Recommendation Report for Planning Permission for Works or Extension to a Dwelling

REF NO: AL/56/20/HH

LOCATION: Norton Dairy
Old Dairy Lane
Norton
Aldingbourne

PROPOSAL: Rear extension and ancillary buildings to existing dwelling. This application may affect the setting of a conservation area.

Mr I Lissamore
1:100 @ A1 July 2020
DRG PL01 rev A

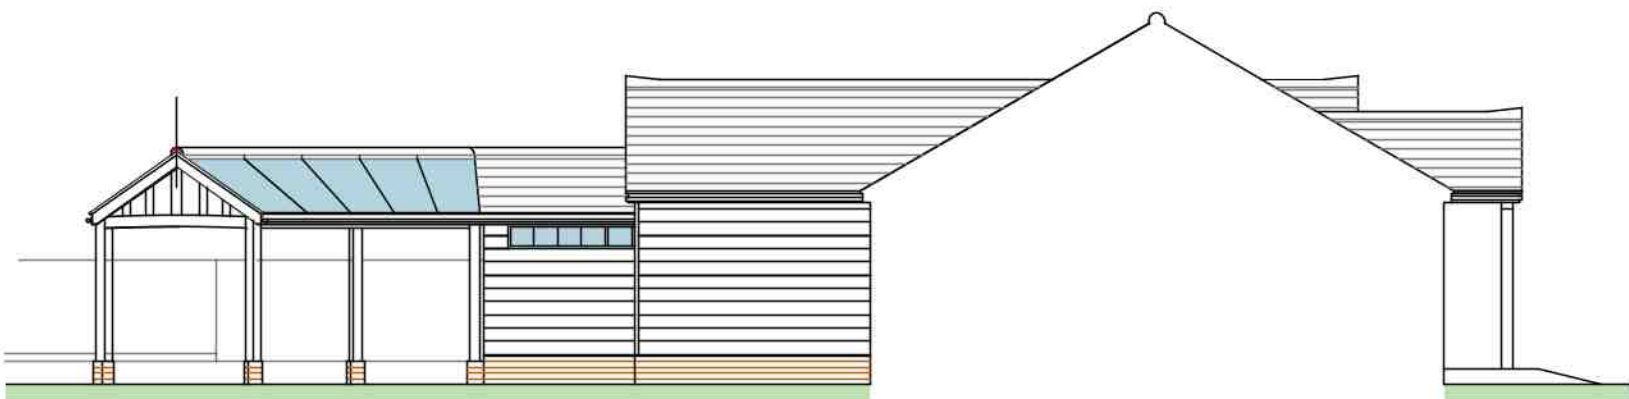
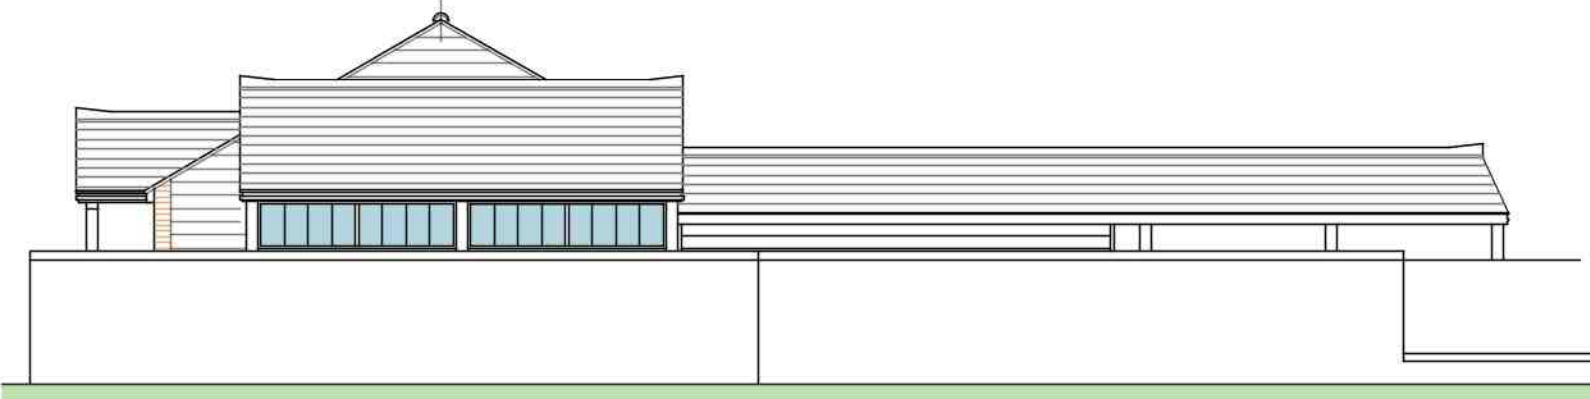
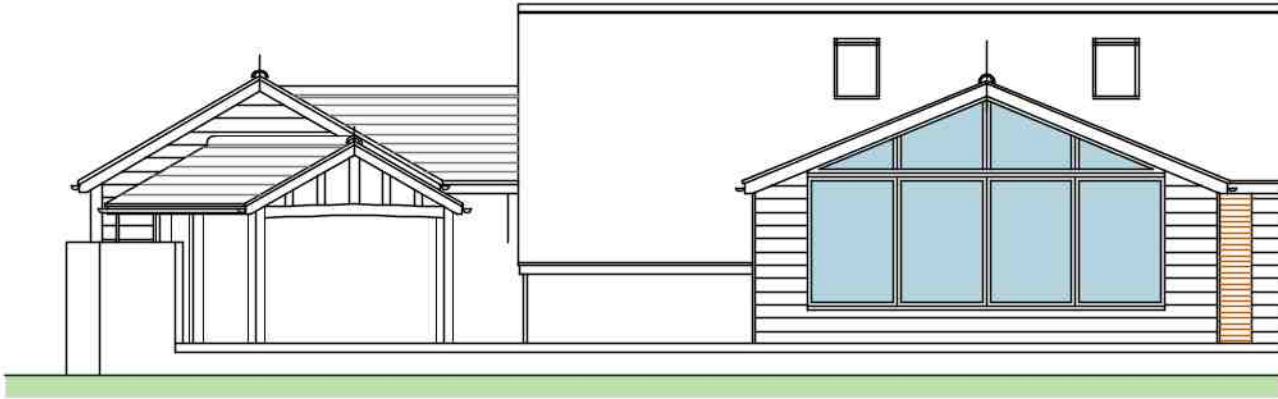
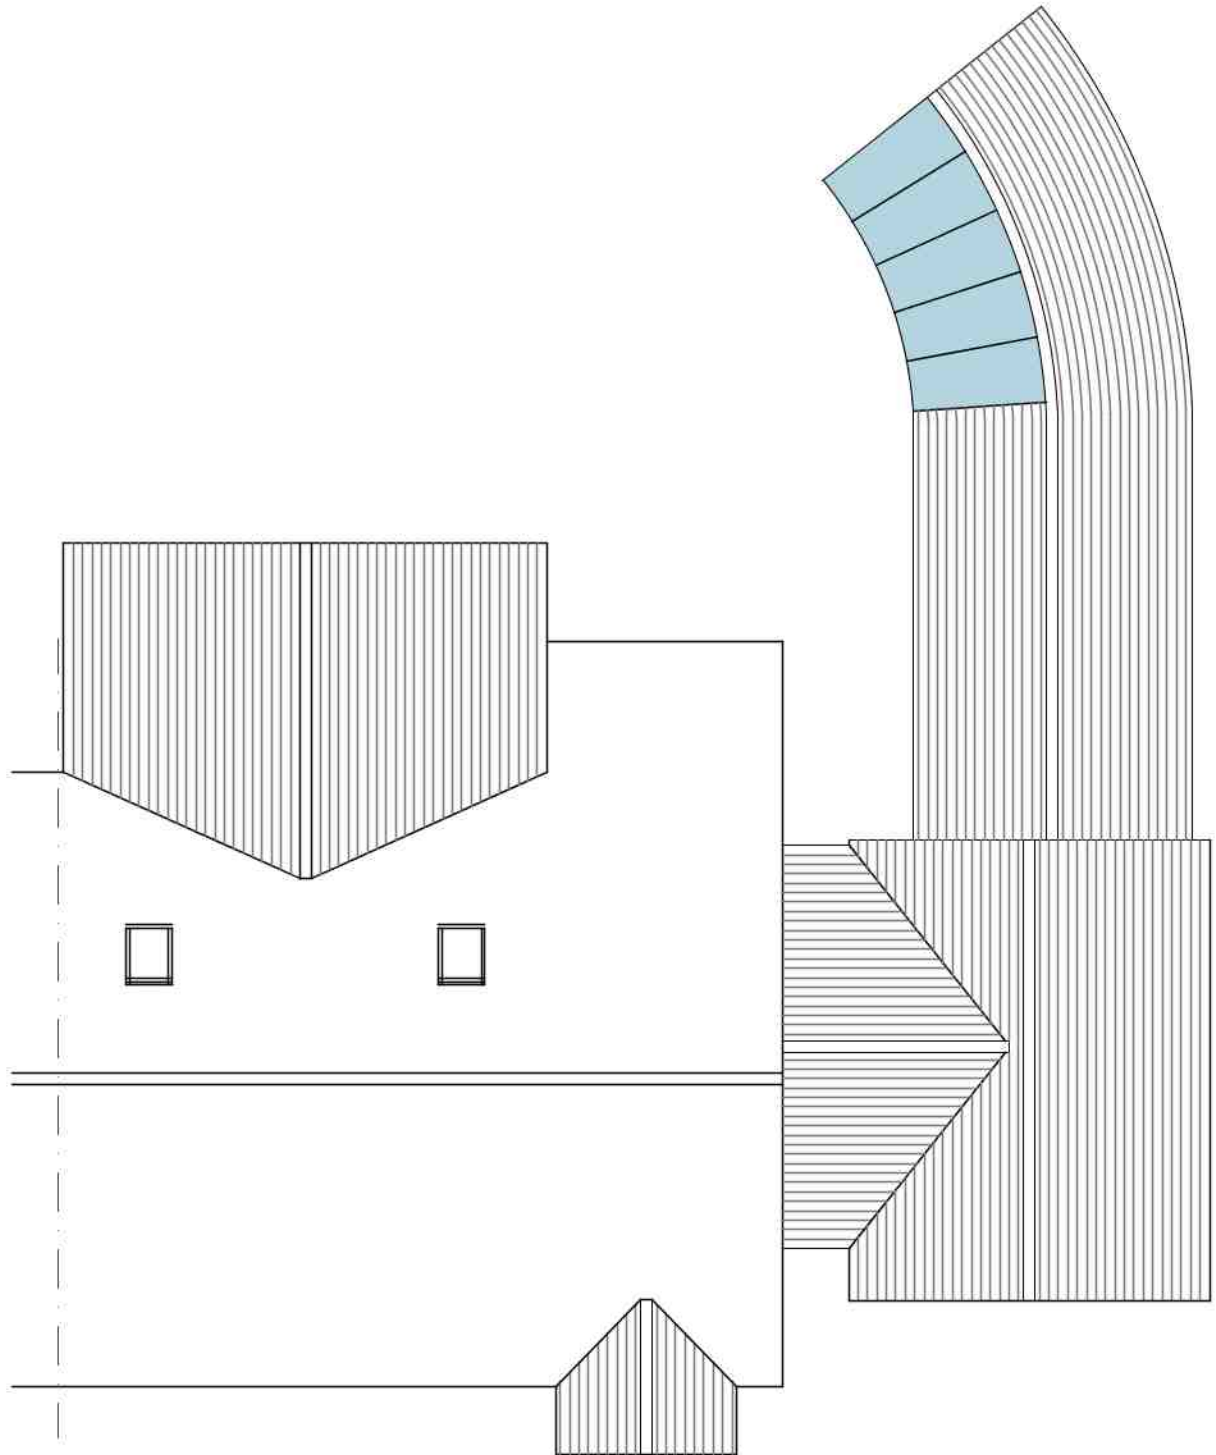
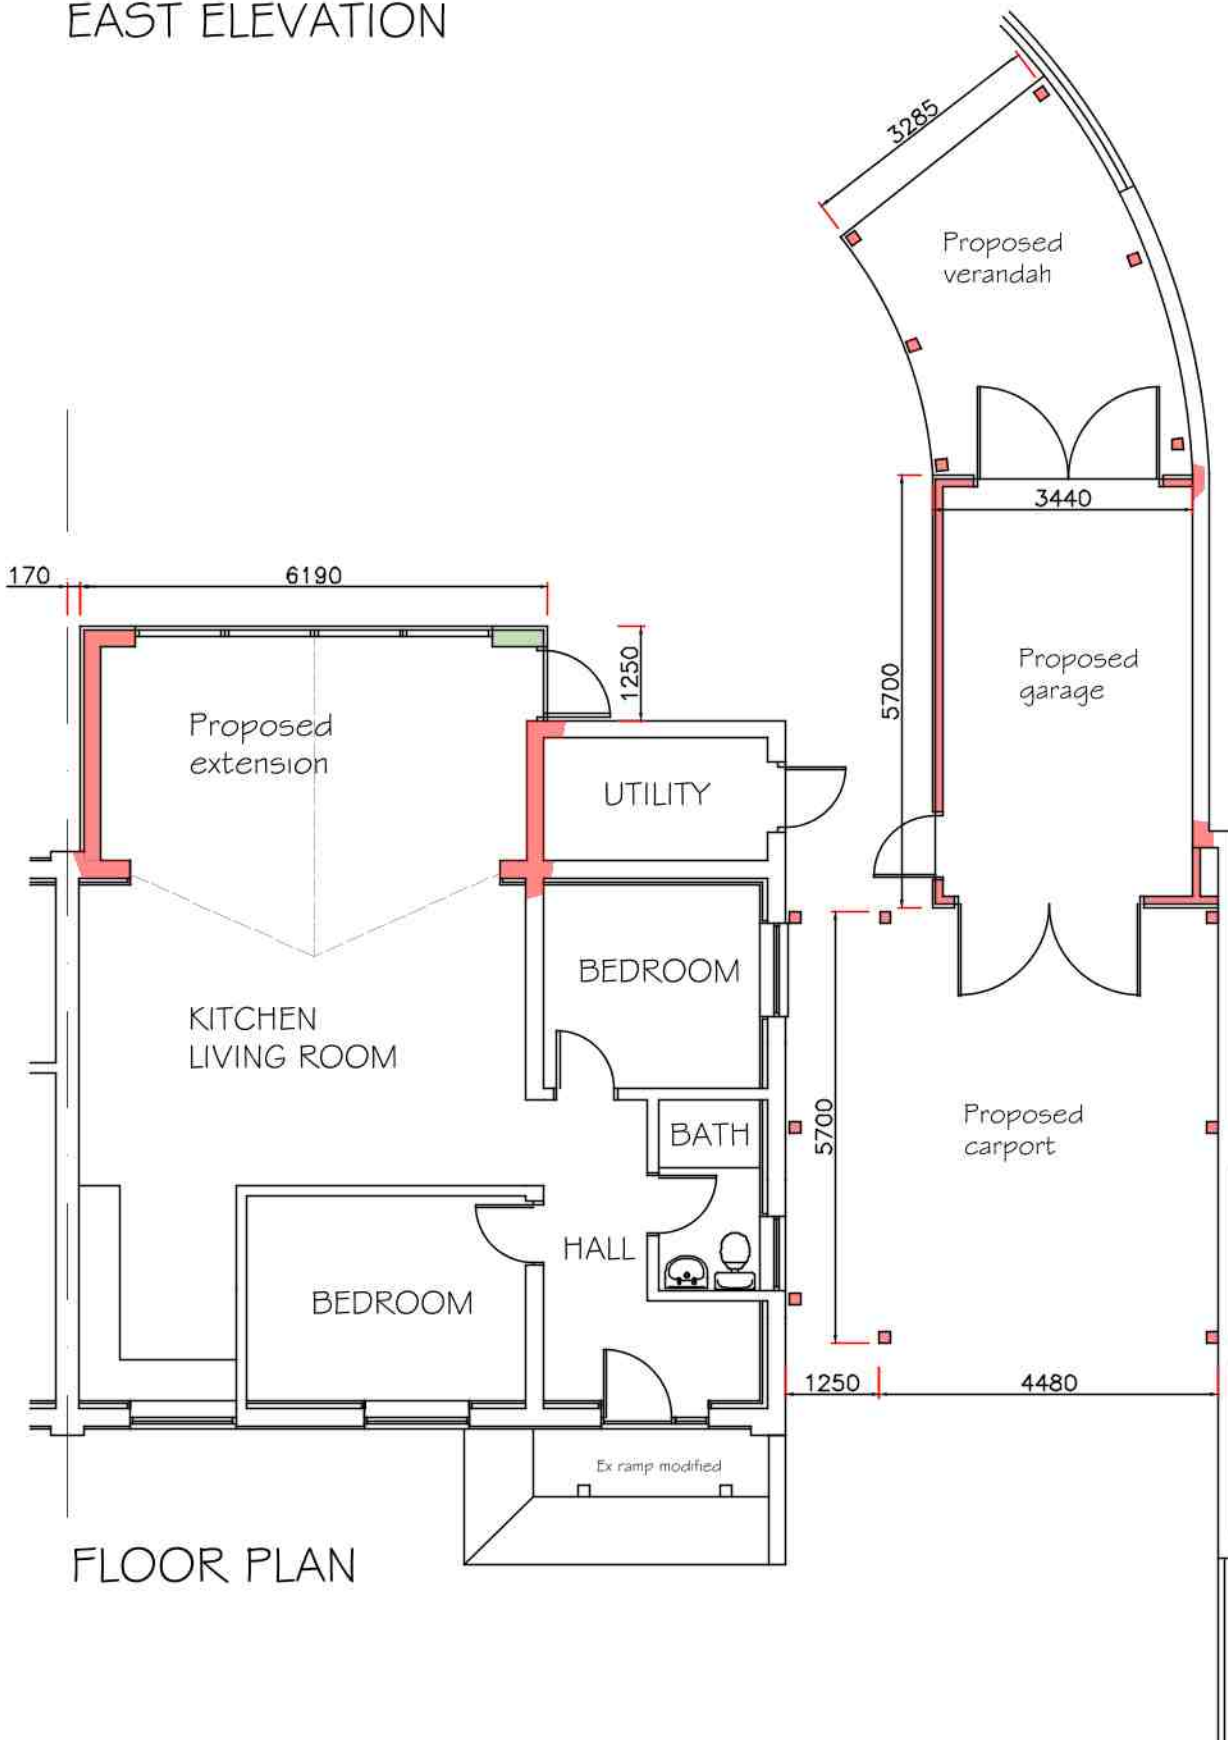
The carport and garage will be located to the north elevation and will run a depth of around 11.5m with a width of 5.7m. This will have a pitched roof to around 4m in height. There will be an additional 5.2m

forming a veranda to the rear which will curve along the boundary. The carport and veranda have wooden posts and a part glass roof and are not enclosed. Whilst the addition adds bulk to the side of the dwelling, with the largely open appearance this helps ensure the structure doesn't appear unduly dominant.

The rear extension is situated to the western elevation and will have depth of 3m and a width of 6.1 where it will meet with an existing building line.

The extension will have a pitched roof with a height of 3.65m with eaves to 2.3m. This will be retain only 0.17m to the boundary. There is a brick wall which runs along the boundary between the host dwelling and the neighbouring property at Easter Cottage and the eaves will sit in line with the wall with the roof extending away from the neighbouring property and as such this is considered to help ensure it does not appear adversely overbearing.

There is a kitchen window to the rear elevation of the neighbouring property which the extension would likely intersect when a 45 degree line is drawn from the centre. However, at a depth of 3m and with the roof design sloping away from the boundary, it is not considered to result in a significant impact in which a refusal is justified.

There will be a large window to the extension however this is not considered to give rise to views which are not already achievable.
